## **Hydro Kurri Kurri Aluminium Smelter Remediation SSD 6666 MOD 1**

### **Additional information required – 8 July 2021**

**Figure 2 |** Proposed location of leachate management infrastructure

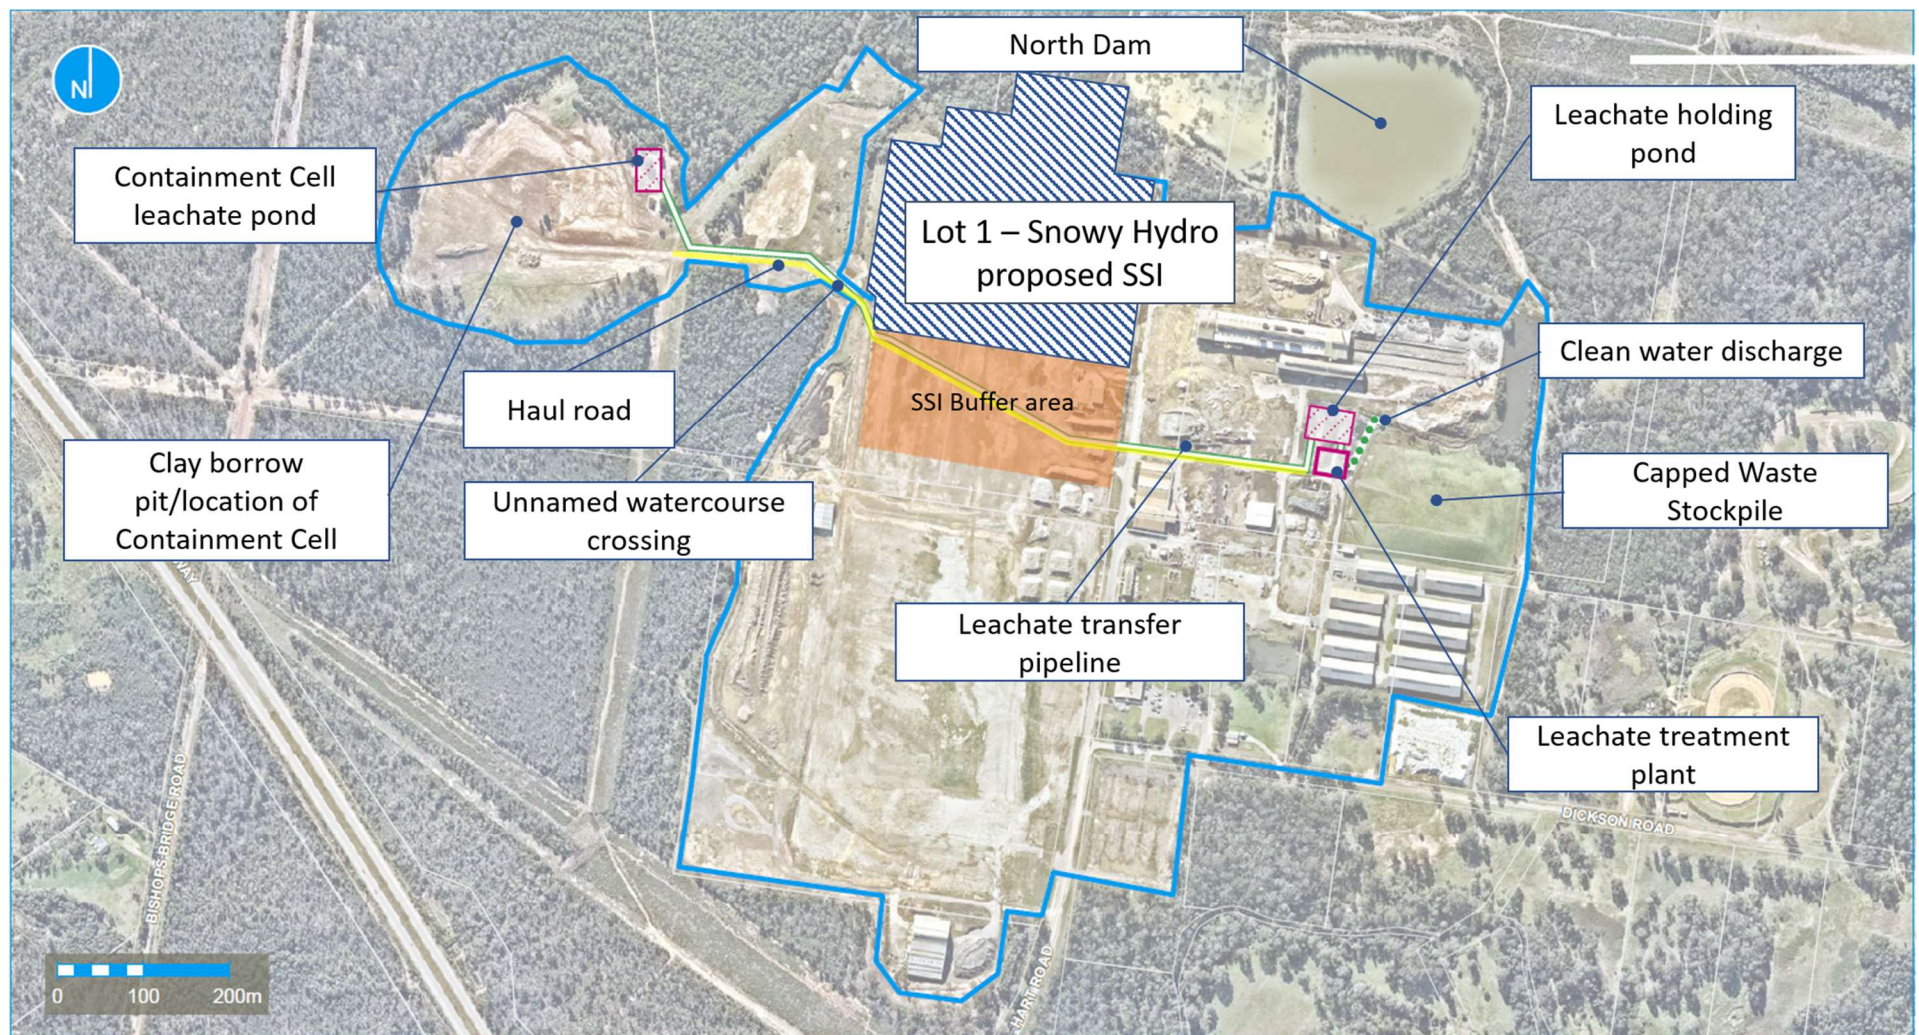
- Diagrammatic representation of the proposed infrastructure (understood to be the revised Figure 3.2)
- The time period for operation of the TWT infrastructure (both maximum and expected duration)
- A direct comparison between the proposed and original approved infrastructure, noting the leachate ponds approved under SSD 6666
- Details of the route of the pipeline between the Containment Cell leachate pond and the TWTP, including how it would interact with and impact the Hunter Power Project site buffer lands and the remediation haul road
- Details of safeguards for the pipeline along its route and access arrangements for monitoring the pipeline for leaks, including under Hart Road, for the duration of operation of the TWTP

The Department notes you have advised that all assessment undertaken in the SEE considers the location of infrastructure as presented in the revised Figure 3.2. However, where necessary please update the relevant impact assessments, including mitigation measures, demonstrating clearly that the modification would have minimal environmental impact.
